## **Development Facilitation Team (DFT) – Review Comments**

**Project No: PR-2020-004757 Date: 02/14/2024      Agenda Item: #2      Zone Atlas Page: NR-BP**

**Request: Accelerated Expiration of Site Plan Application For The Previously Approved RV Storage Development On Volcano Rd (Si-2021-00307 SITE PLAN)**

**Application For: SI-2024-00157 – ACCELERATED EXPIRATION OF SITE PLAN**

**RV STORAGE - ALBUQUERQUE
 ALBUQUERQUE, NEW MEXICO
 SITE PLAN
 GRADING AND DRAINAGE PLAN**

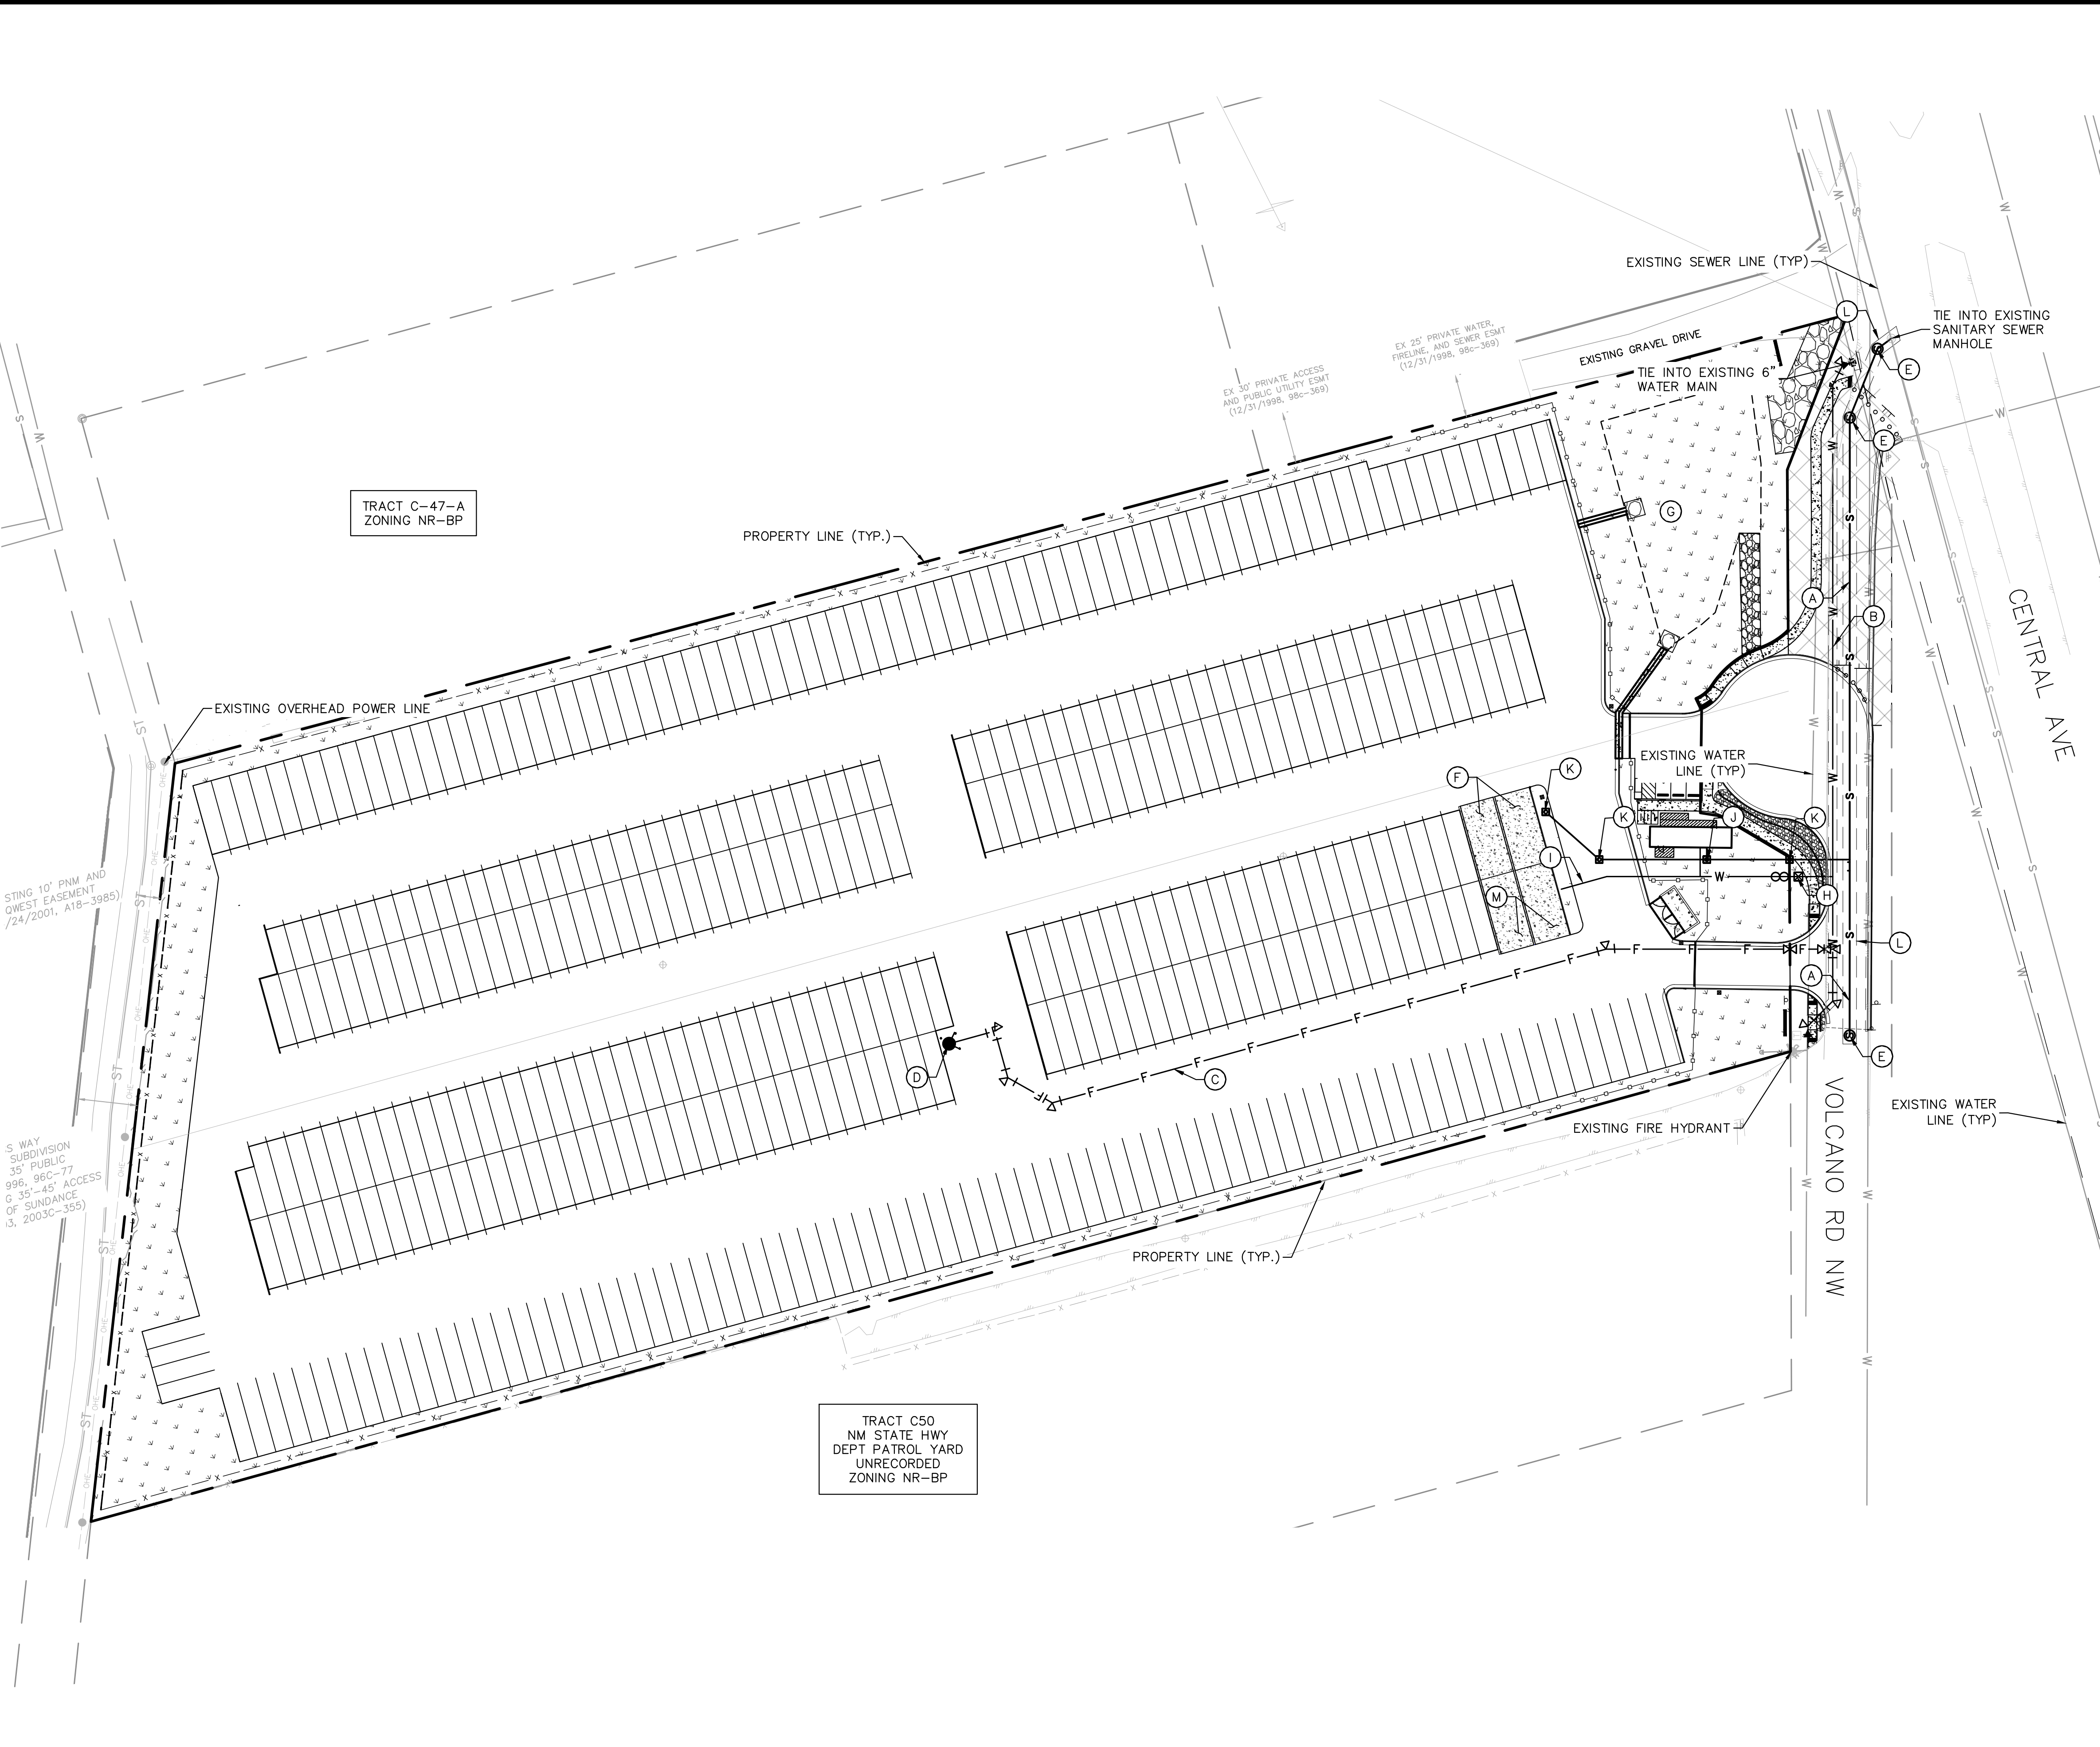
- Hydrology has no objection to the accelerated expiration of the Site Plan for Building Permit.
- Hydrology has no objection to the accelerated expiration of the Infrastructure List and returning the Financial Guarantee.
- Comment – Hydrology also voids the approval of the Conceptual Grading & Drainage Plan for this site. If the development at this site wishes to move forward, an updated Conceptual Grading & Drainage will have to be submitted to Hydrology for approval
